From: Anita Gardner
Sent: 26 March 2018 10:18
To: Planning.Responses
Subject: FW: Revision to objection Planning Application EP/7/18/PL

From: [REDACTED]
Sent: 23 March 2018 14:44
To: Anita Gardner
Subject: Revision to objection Planning Application EP/7/18/PL

Elevations of new stircase to existing building

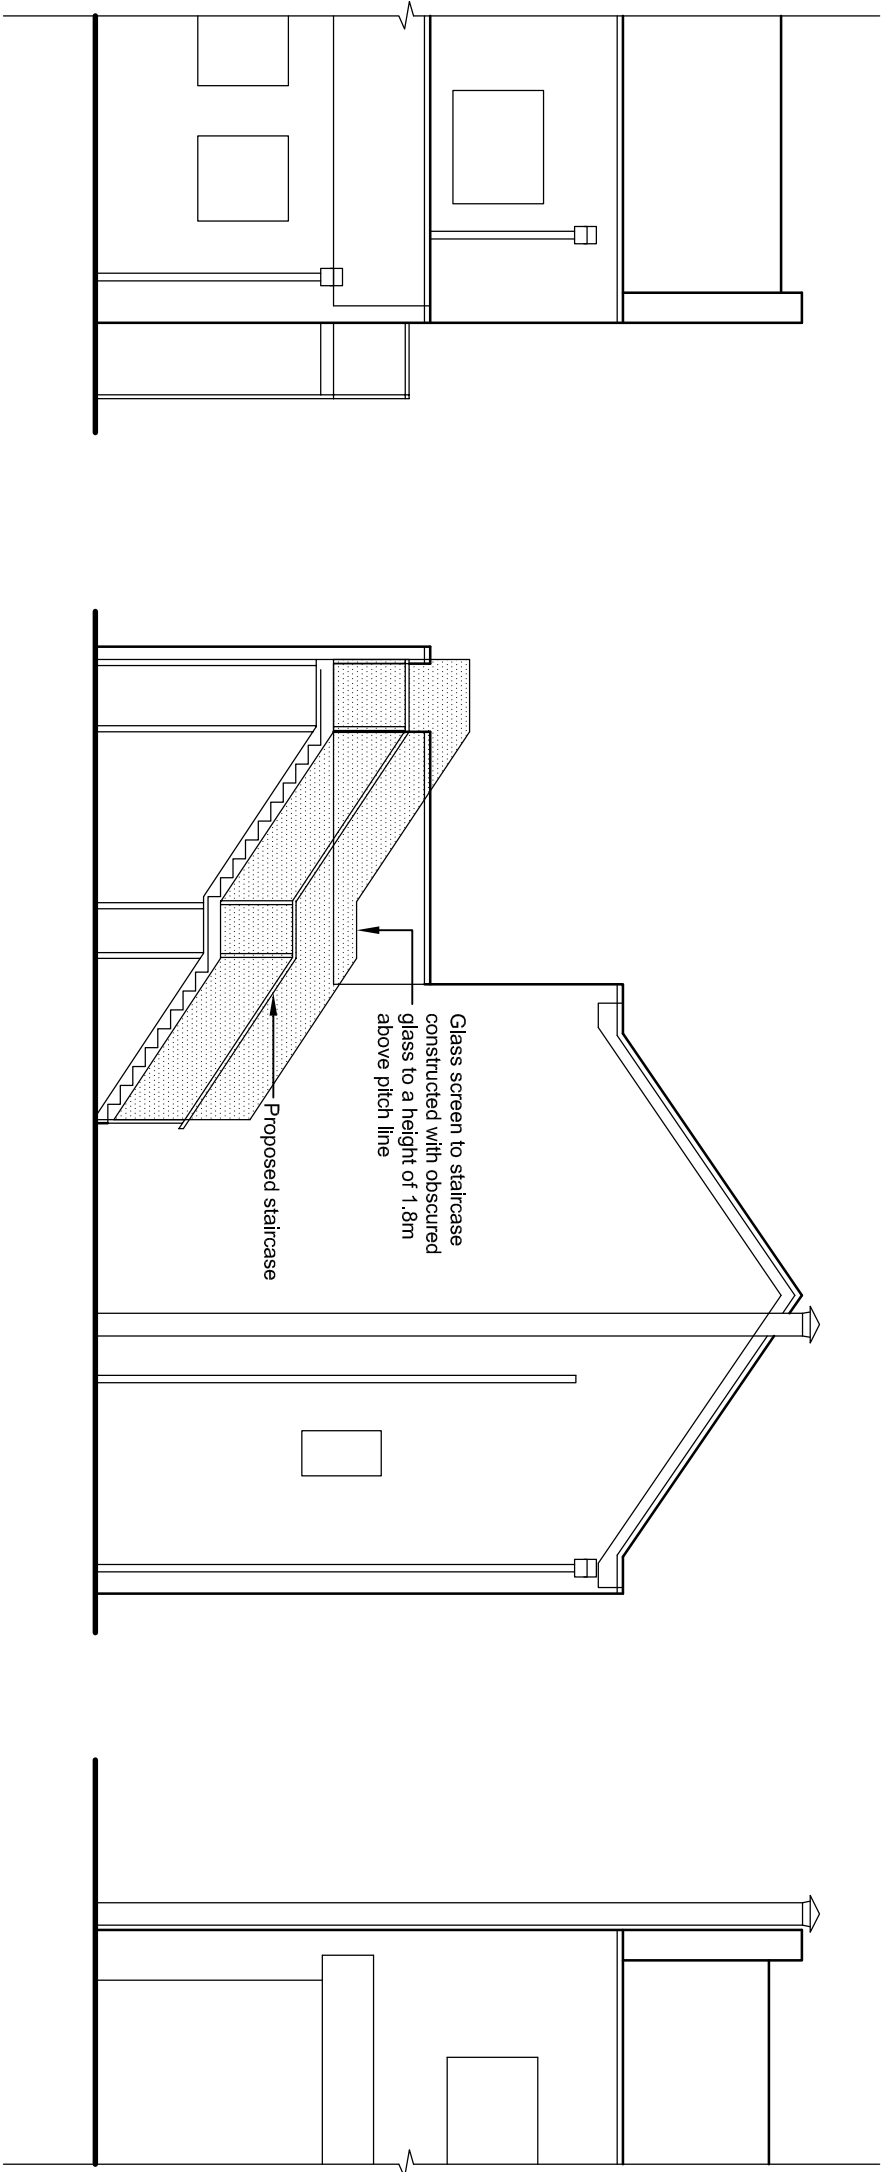
"As an escape route it would require the unlocking of the inward opening gate at the end of the alleyway which has been closed to all since the mid-eighties, this to allow permanent egress/ access to anyone, as yet no detail has been provided as to how this could be controlled. The gate should open out not in and have an efficient controlled device to prevent it being left open for access by all and sundry, panic bars are designed for internal doors and do not close gates." ...

However it would seem the Landlord has pre-empted any planning decision by instructing his contractors this morning to install a new gate at the end of the disputed alleyway (which we are claiming by adverse possession.)

You will note from the photograph it is *not* as detailed in your previous email as it has a domestic (internal) Yale type key operated cylinder/latch.

It opens in and would not accept a panic bar.
